Portishead Branch Line (MetroWest Phase 1)

Planning Inspectorate Reference: TR040011 Applicant: North Somerset District Council

9.3.3 ExA.SoCG-EA.D5.V3 - Statement of Common Ground

Date: February 2021

Drawing Title: CATTLE CREEP PROPOSED GENERAL ARRANGEMENT SHEET 1 OF 2

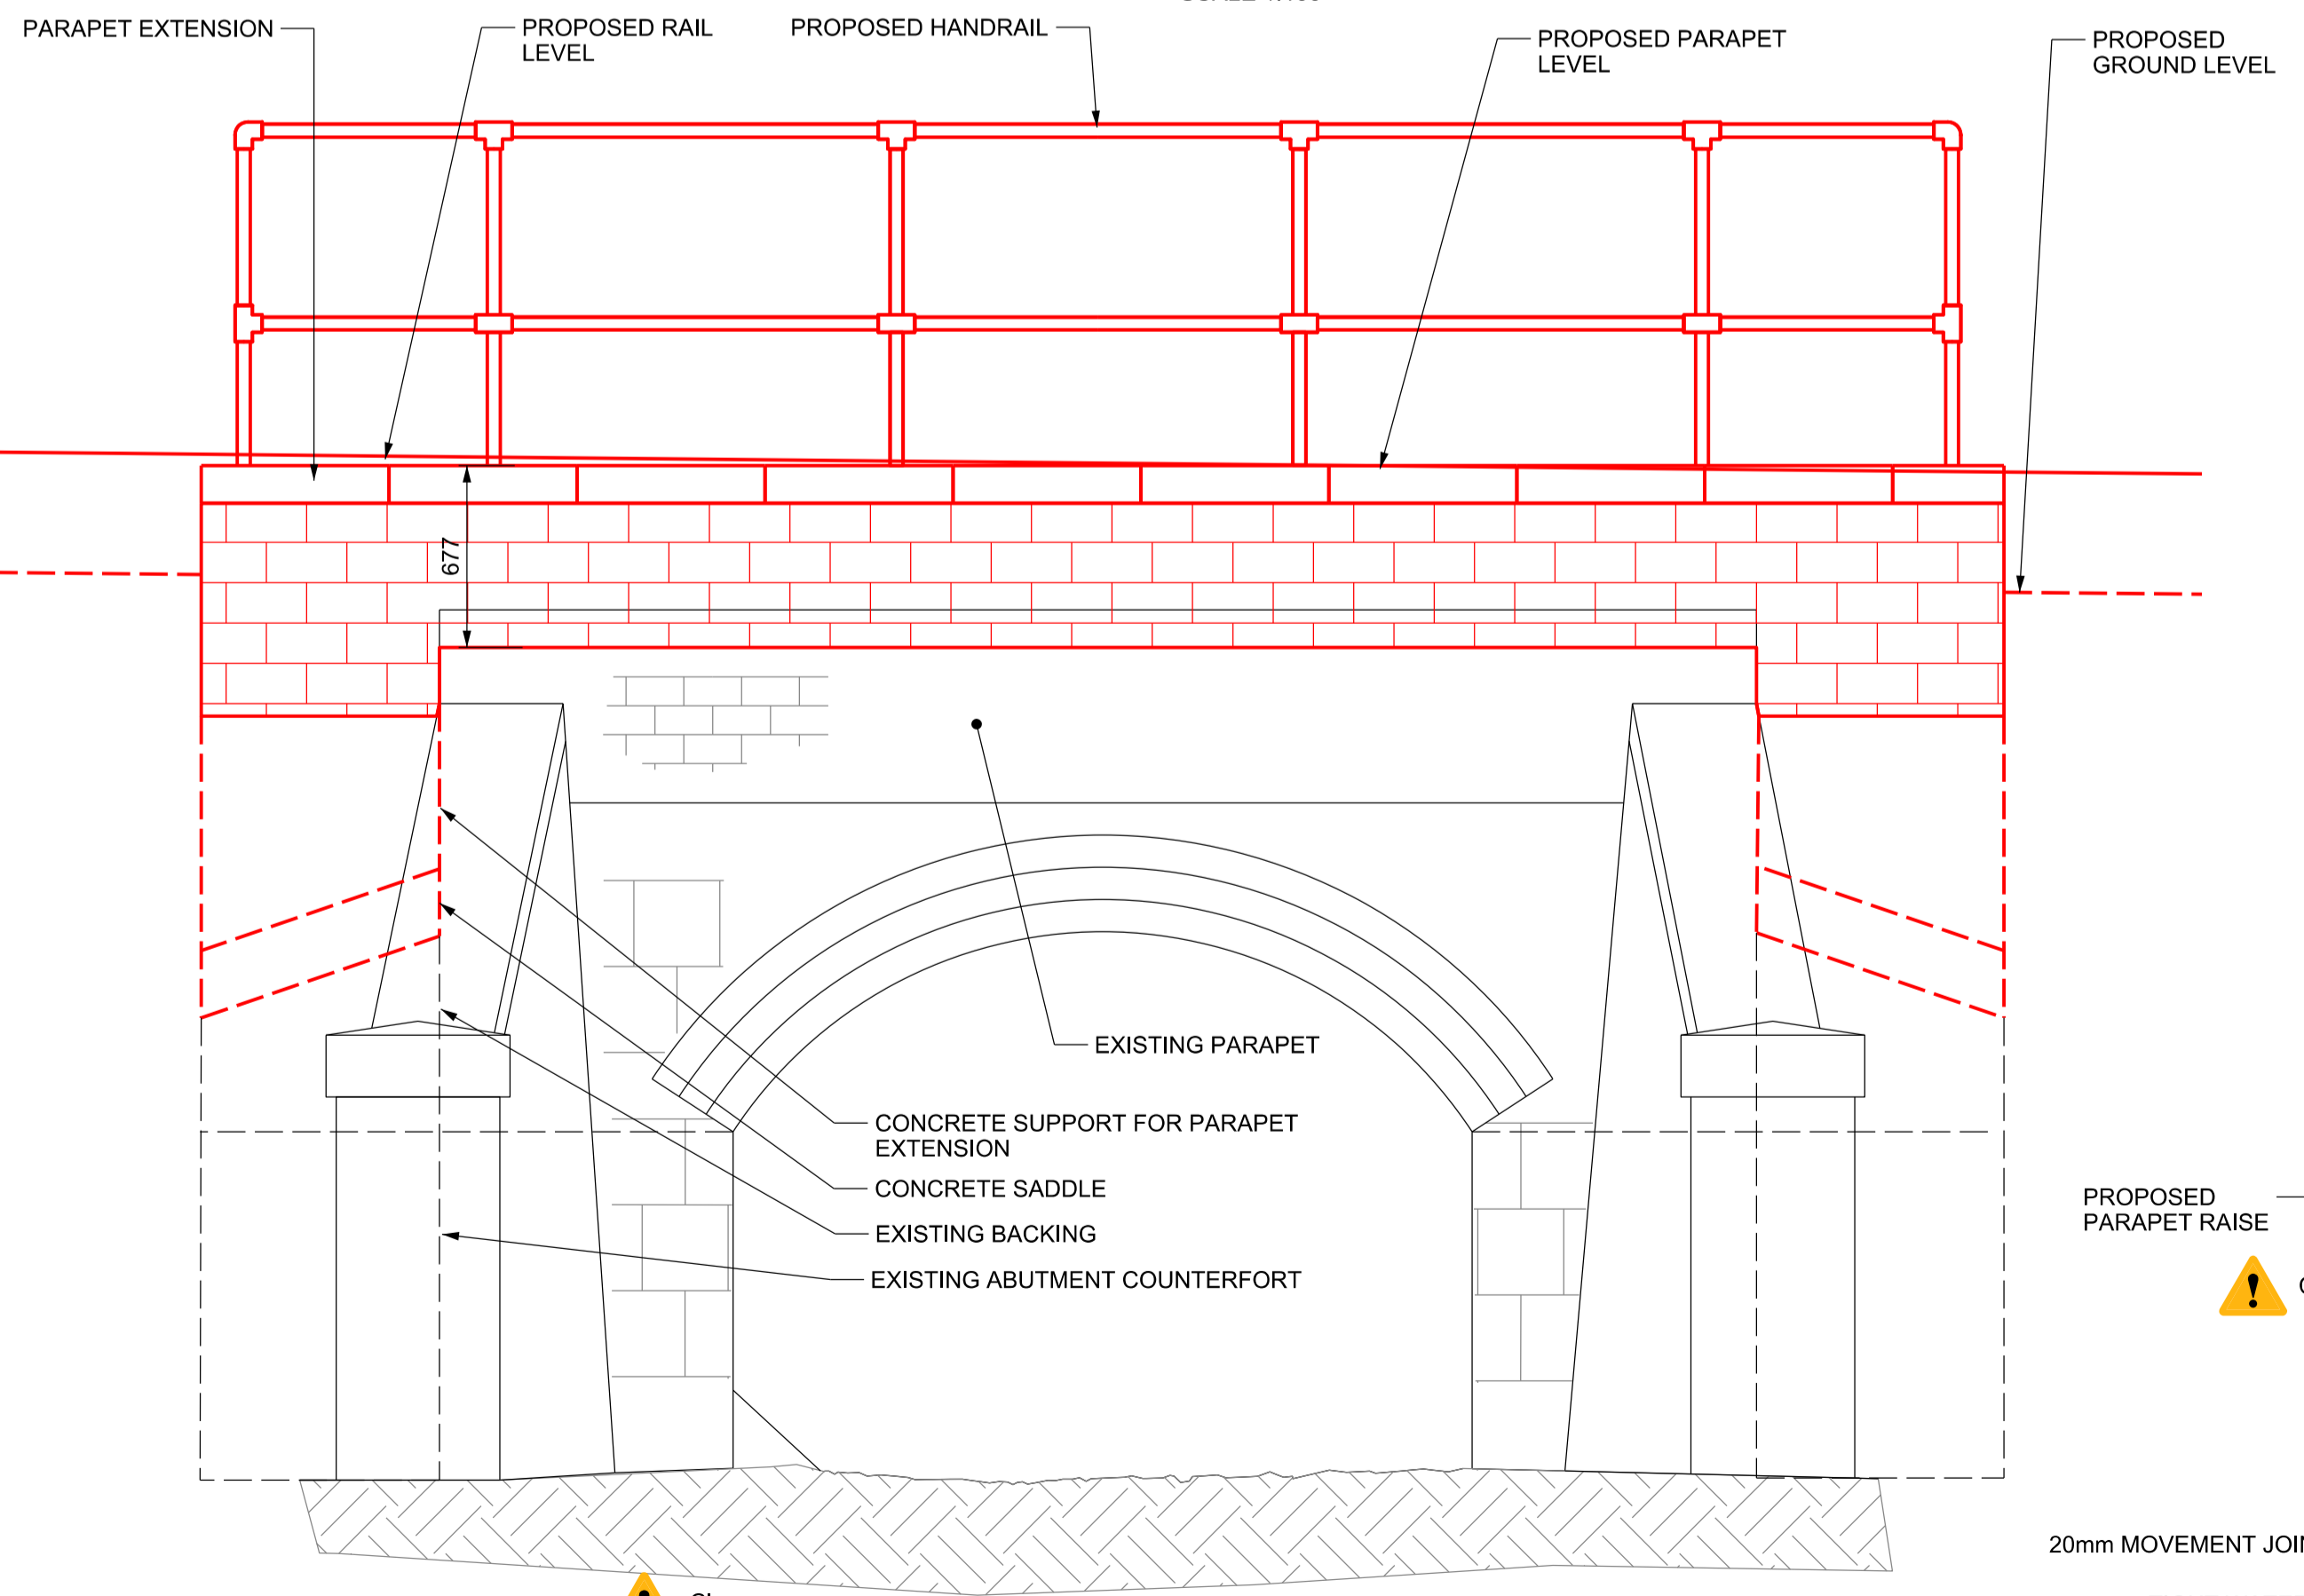
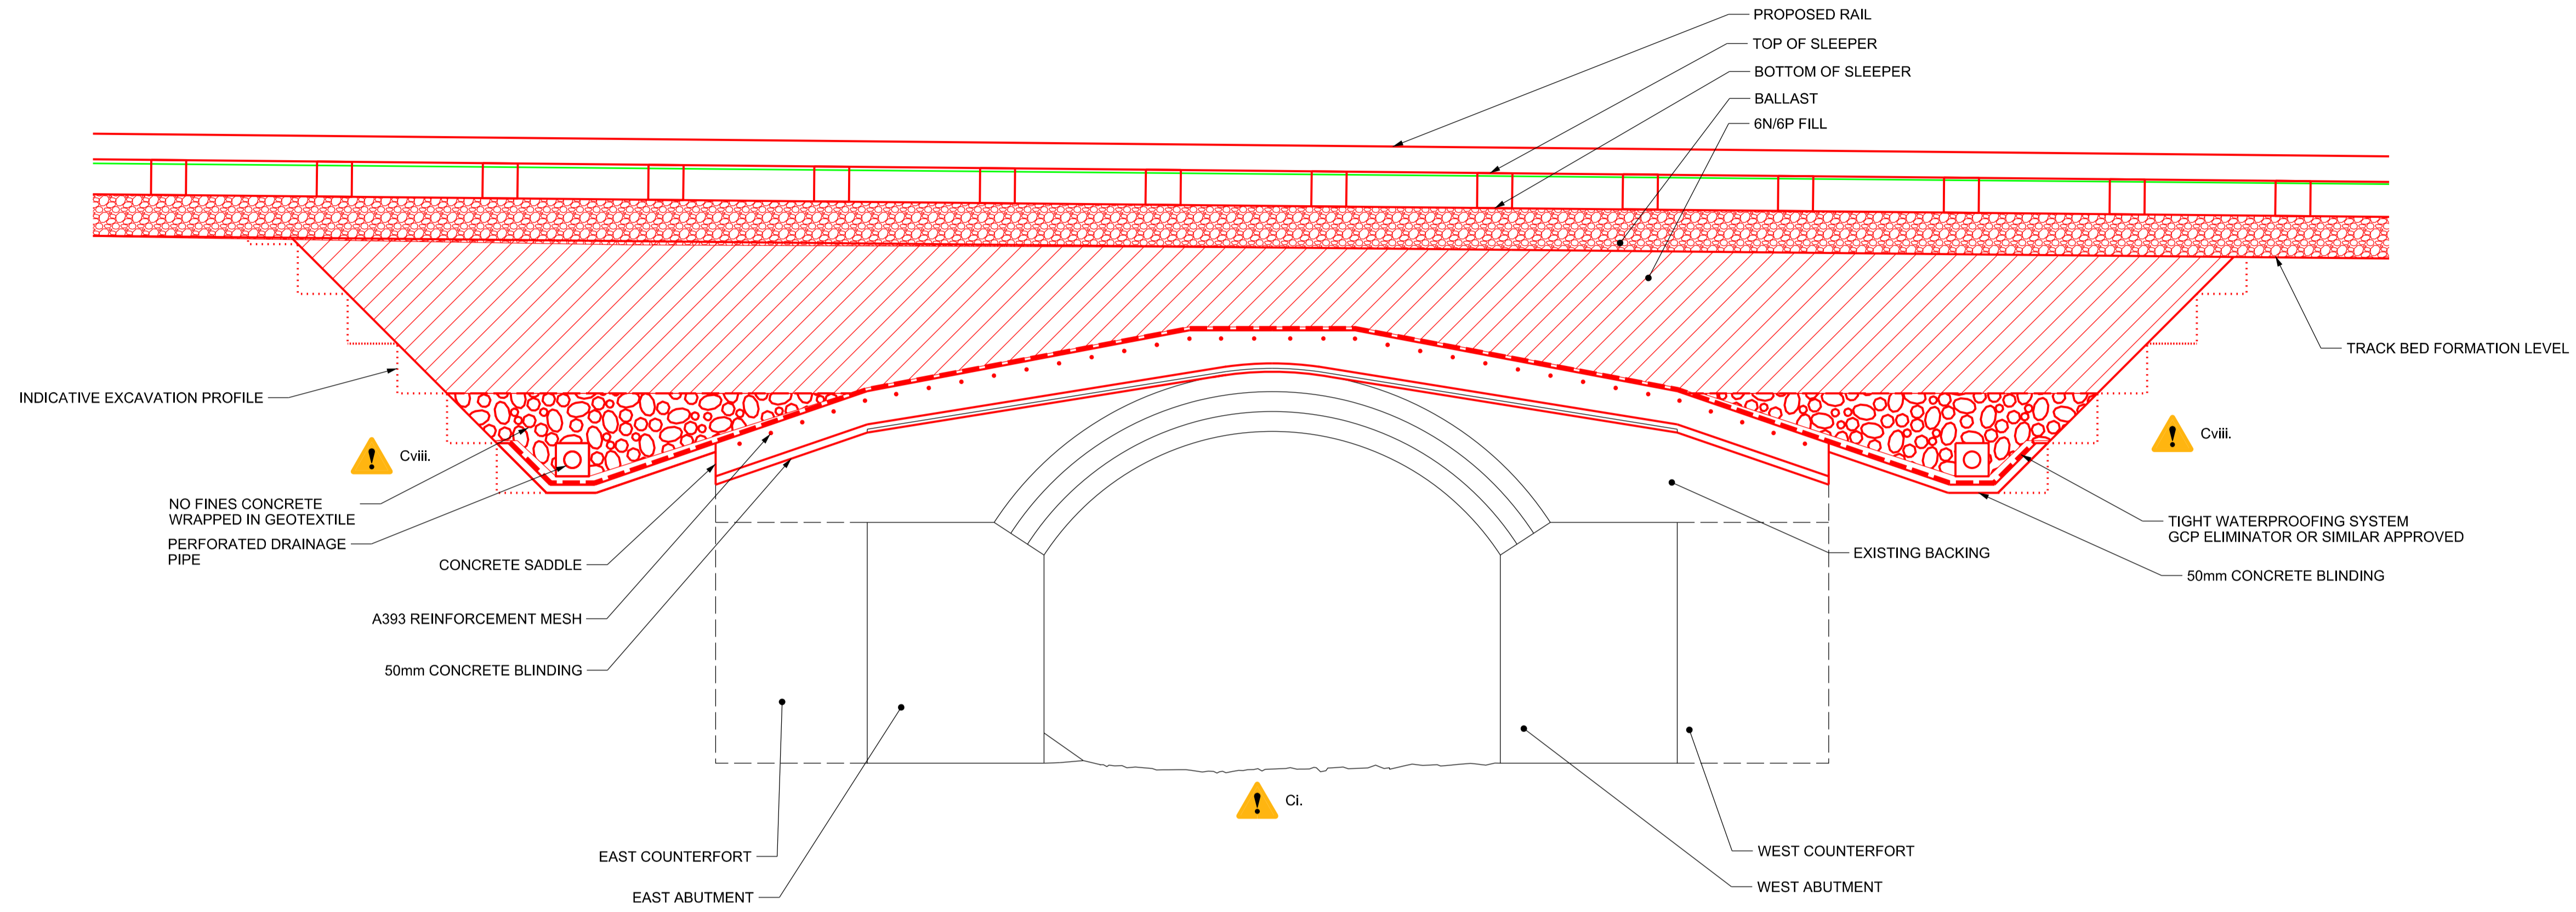
5.1.9	Easton in Gordano Stream	The EA agrees that specific flood compensation is not required however, this relies on a flood relief channel in the form of a farm access track running under the railway line. As a result, appropriate provisions are required within the DCO,	There are no plans to block Cattle Creep access track and it will be maintained in its current form.	Issue Outstanding: The Applicant is considering a requirement text for Cattle Creep access track as follows: 33.— (1) Work No. 1B must not commence before the undertaker has provided to the relevant planning authority and the Environment Agency

Ref	Торіс	Environment Agency position	Applicant position	Status (Issue Resolved/Issue Outstanding)
				a topographic survey setting out the existing ground levels at Cattle Creep bridge, Easton in Gordano. (2) Works to Cattle Creep Bridge must be carried out in accordance with the principles set out in the Cattle Creep Proposed General Arrangement drawing and in particular the arch of the Cattle Creep Underbridge must not be altered and the ground level beneath the Cattle Creep Underbridge must not be raised without the prior consent in writing of the relevant planning authority following consultation with the Environment Agency and (if relevant) the lead local flood authority
